CITY OF ALBUQUERQUE

August 29, 2014

**Re: Beehive Homes Phase I
13440 Wenonah Ave SE
Request Permanent C.O. – Not Accepted
Engineer's Stamp dated: 10-4-13 (L23D022)
Certification dated: 8-27-14**

ENGINEER'S SEAL	BEEHIVE HOMES	DRAWN BY WCWJ
	GRADING AND DRAINAGE DETAILS	DATE 10-02-13
		SHEET # 2
DAVID SOULE P.E. #14522	1606 CENTRAL AVENUE SUITE 201 ALBUQUERQUE, NM 87106 (505) 872-0999	JOB # 21227

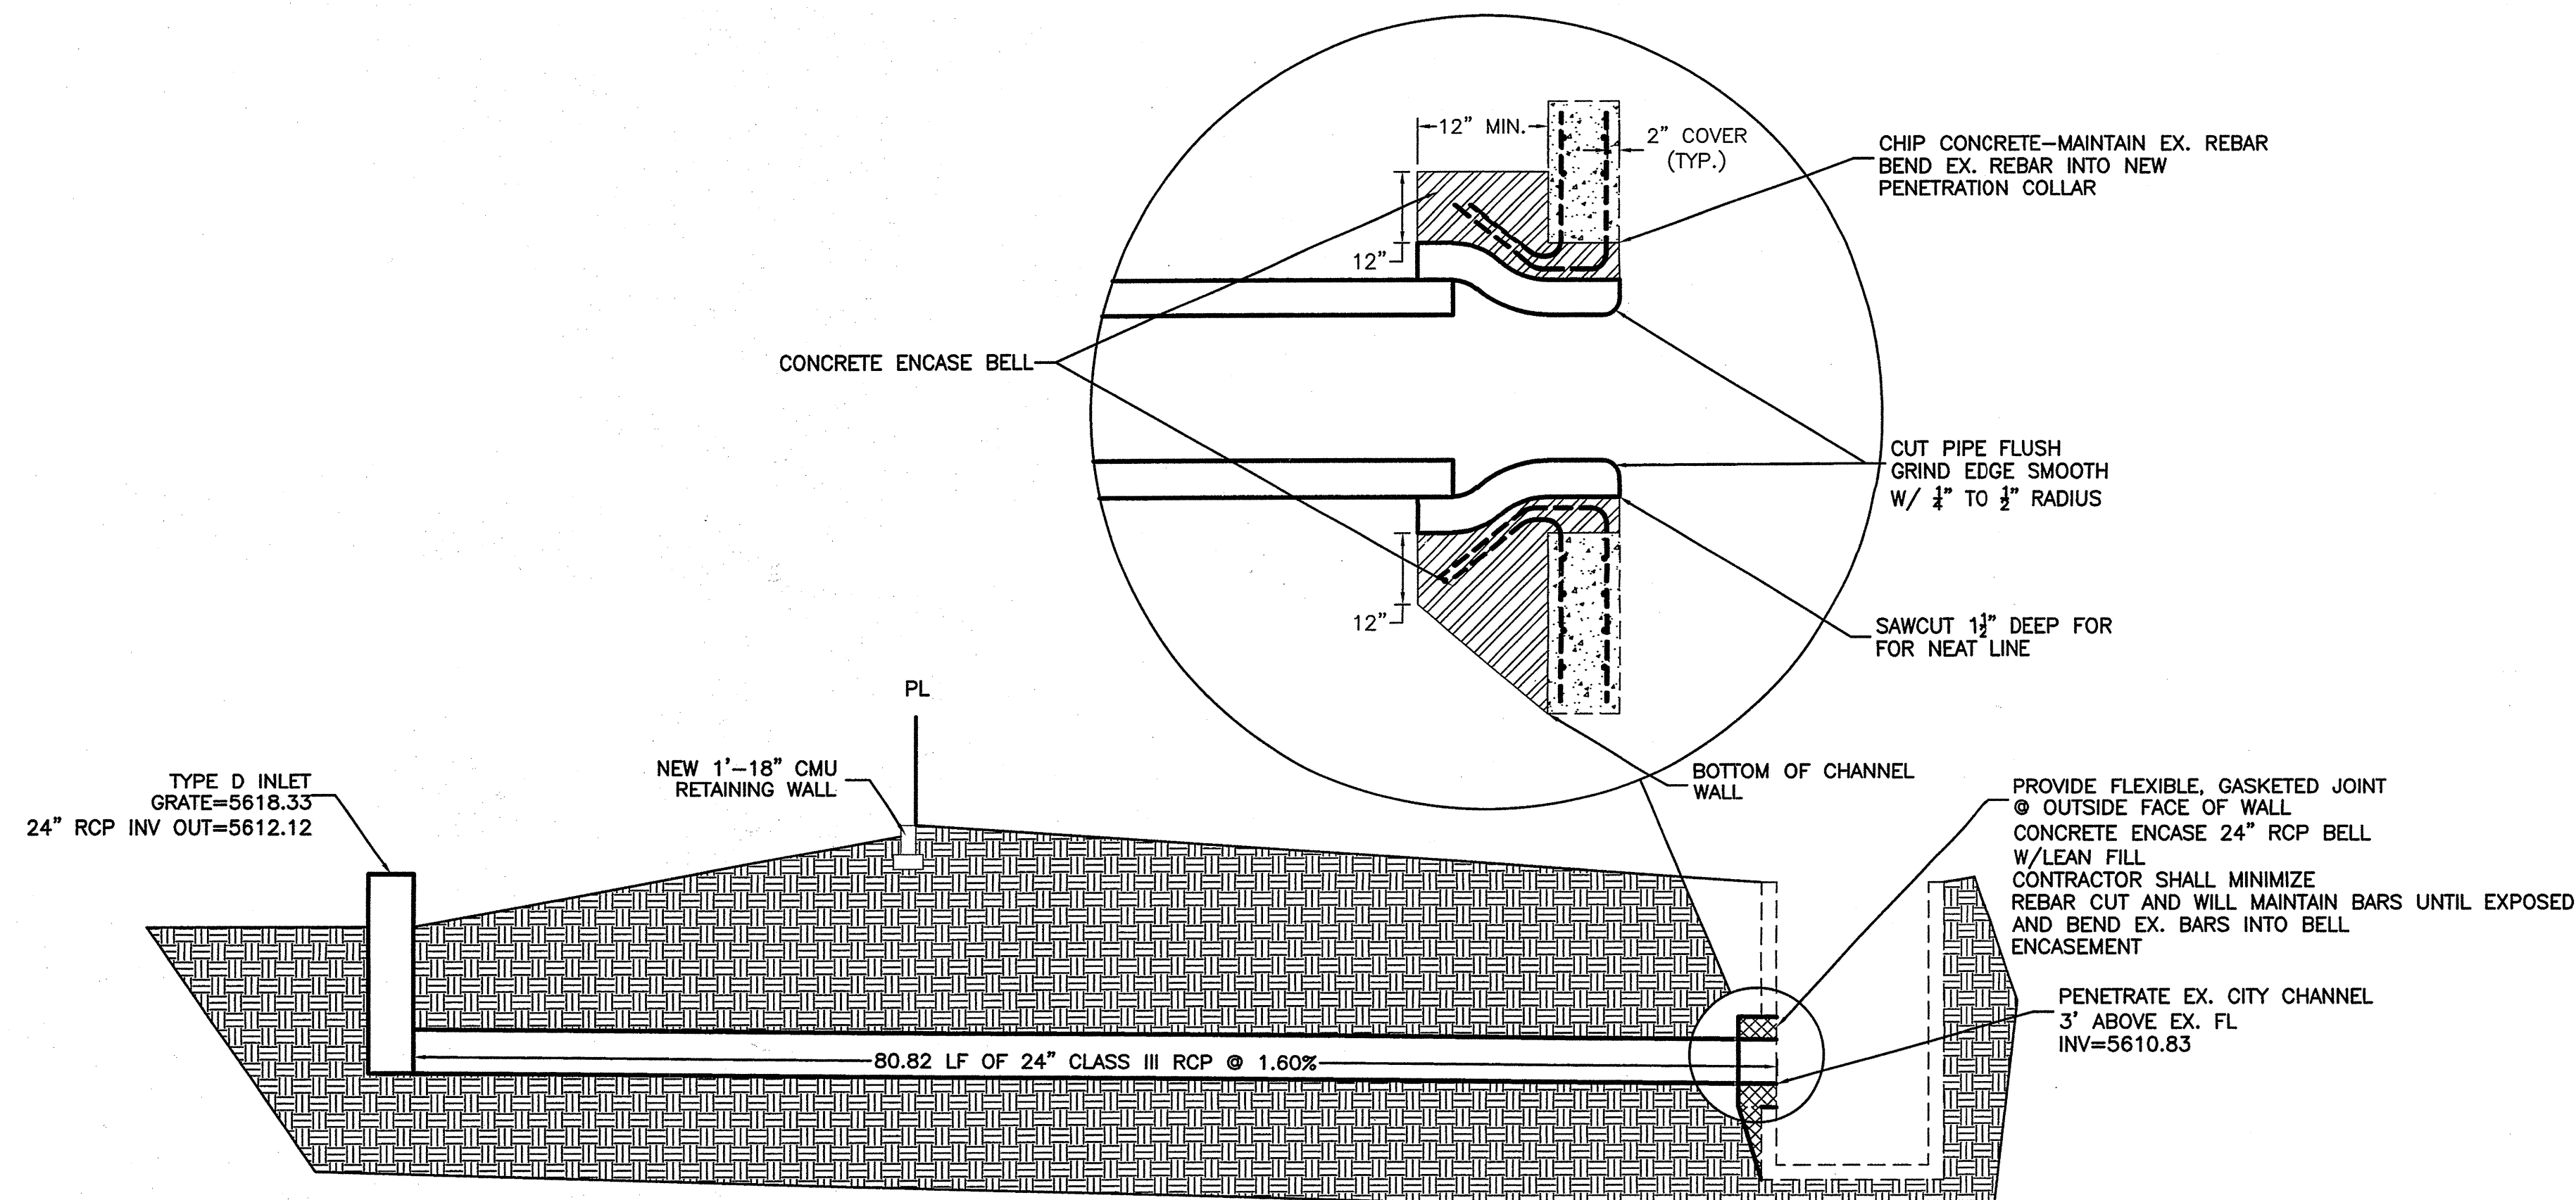
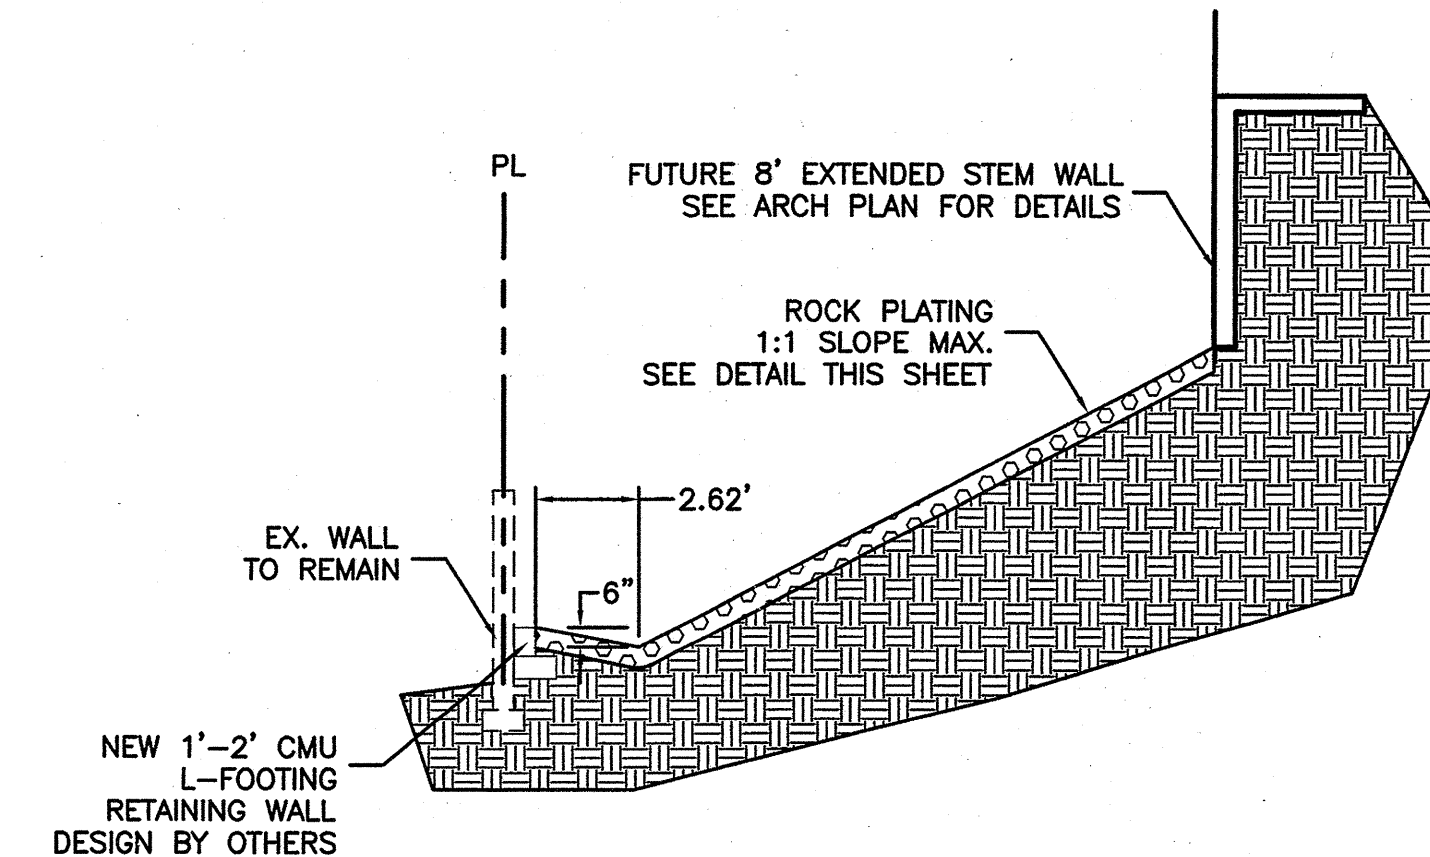
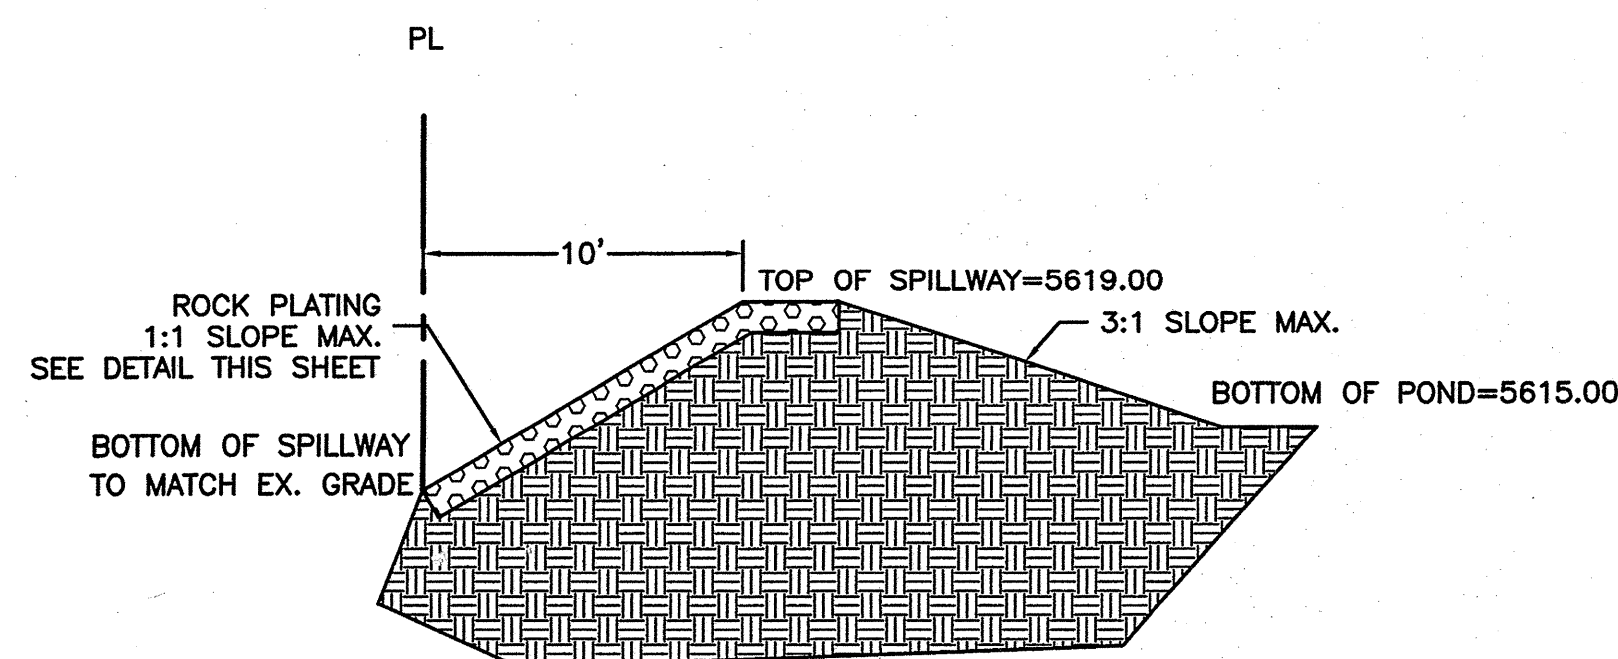
- Sections A-A, B-B and C-C were not certified or built per the approved Grading and Drainage plan, dated 10-4-13, provided by Rio Grande Engineering.
 1. The rock plating was not constructed. If a concrete slope paving is used, the header wall will need to be raised to prevent the water from jumping the header wall and under mining the footer.

2. The spillway was not constructed according to the section provided.
- Erosion is occurring on the east side of the structure at the down spouts. This may cause possible damage to the structures footings.

ENGINEER'S SEAL	BEEHIVE HOMES	DRAWN BY WCUJ
DAVID SOULE NEW MEXICO REGISTERED PROFESSIONAL ENGINEER 14522	GRADING AND DRAINAGE PLAN	DATE 10-02-13
	Rio Grande Engineering 1606 CENTRAL AVENUE SUITE 201 ALBUQUERQUE, NM 87106 (505) 872-0999	21227-AYOUT-7-13-12
		SHEET # 1
		JOB # 21227

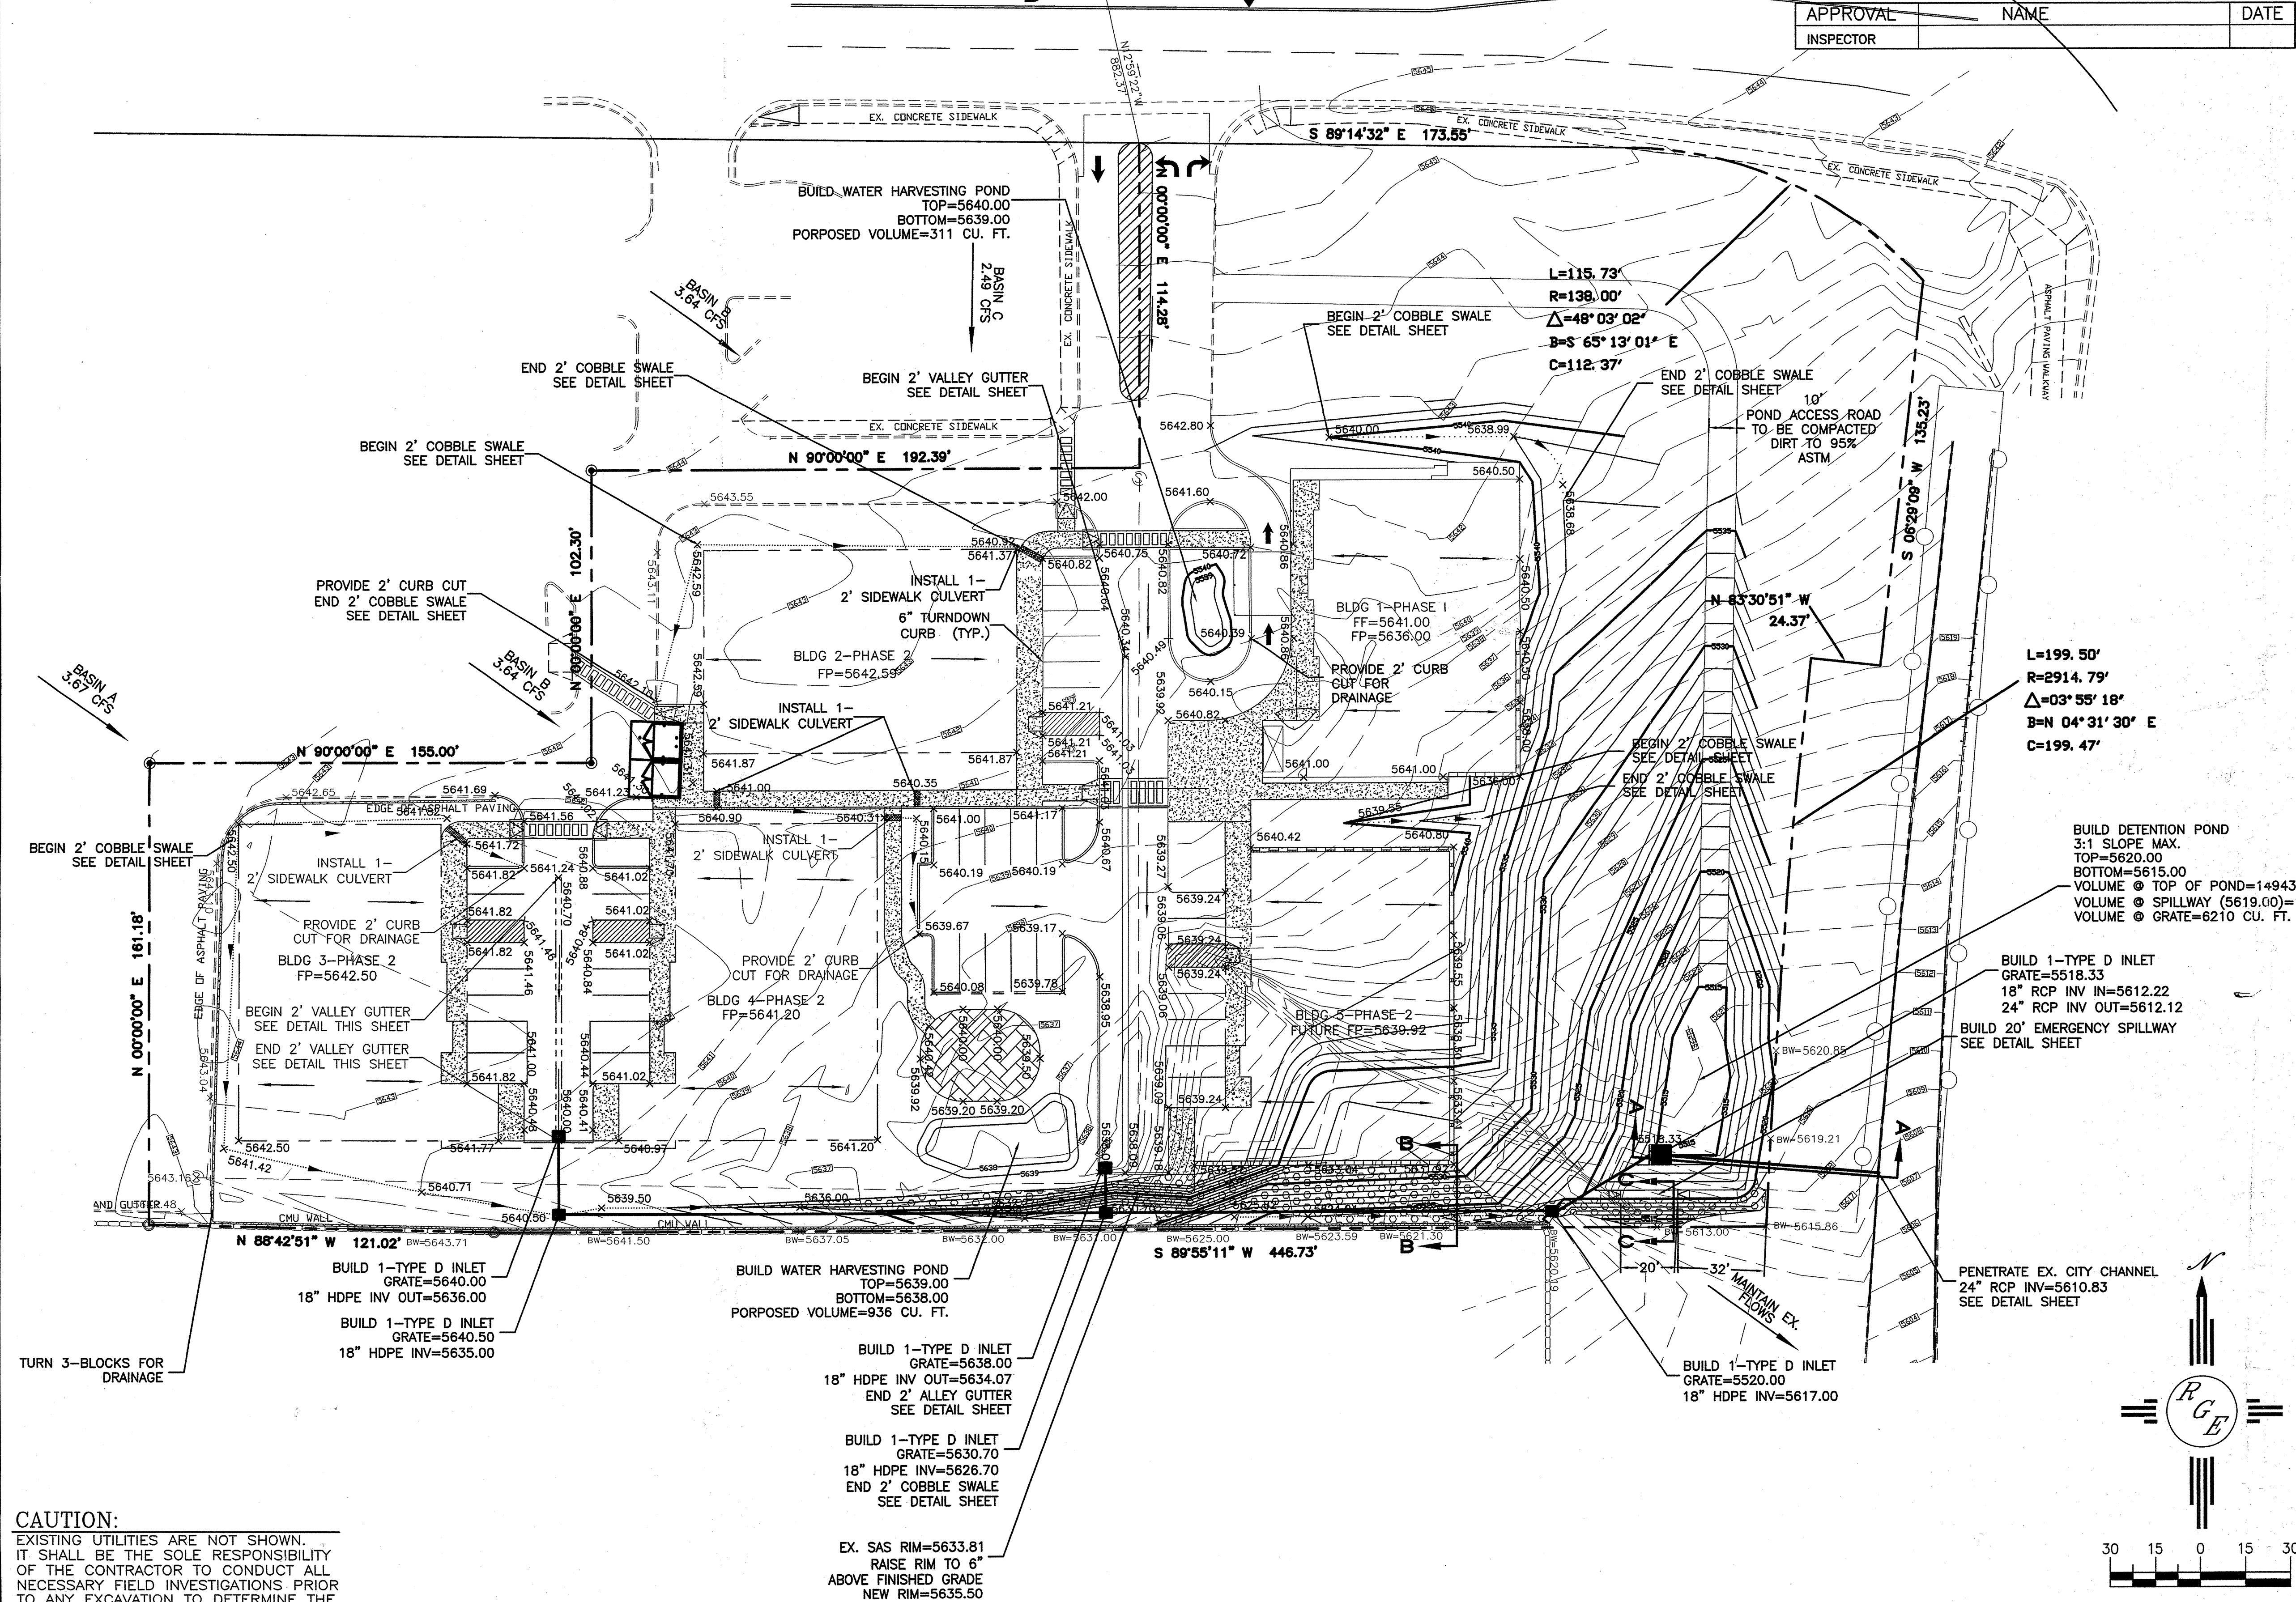
Hydrology's biggest concern is the unprotected steep slope on the south side of the property and the amount of sediment entering the southern channel and possibly the onsite storm drain.

- The east side of the property may need a better erosion protection system, to avoid the slope from eroding. This erosion will cause the bottom of the pond to rise with sediment, in return sending sediment into the storm sewer system.

- All phases need to be provided with some type of erosion protection system. Sediment was released into the inlet at the end of the private drive. The private drive was also covered with sediment.

- Waddles must be removed from inlet. In the area of the bottom inlet at the end of the private drive, an overflow occurred and caused erosion at the bottom of the existing CMU wall, also causing the lava rock to be filled with sediment.

- The pond access road needs to be defined. As it sits, motor vehicles will cause ruts and gouges causing erosion to occur.
- At the east side of the property near the channel is a low spot which will allow for water to enter and cause erosion. Some type of erosion prevention system along the channel may need to be installed.
- Sediment is entering the handicap parking space through the sidewalk culvert. This needs to be corrected with an erosion protection system.
- The cobble swale from the north to the east is not depicted according to the site. There is also a concrete pad on the east side of the structure not depicted.
- Ponding is occurring at the dumpster, you may want to address this situation.

Based on the Certification received 8/27/2014, the site is not acceptable for release of Certificate of Occupancy by Hydrology. Numerous items are listed below that were not built are issues. Changes in design have surpassed the level of being able to as-built them on the approved plan. Therefore, submit a grading and drainage plan for Building Permit approval for all phases.
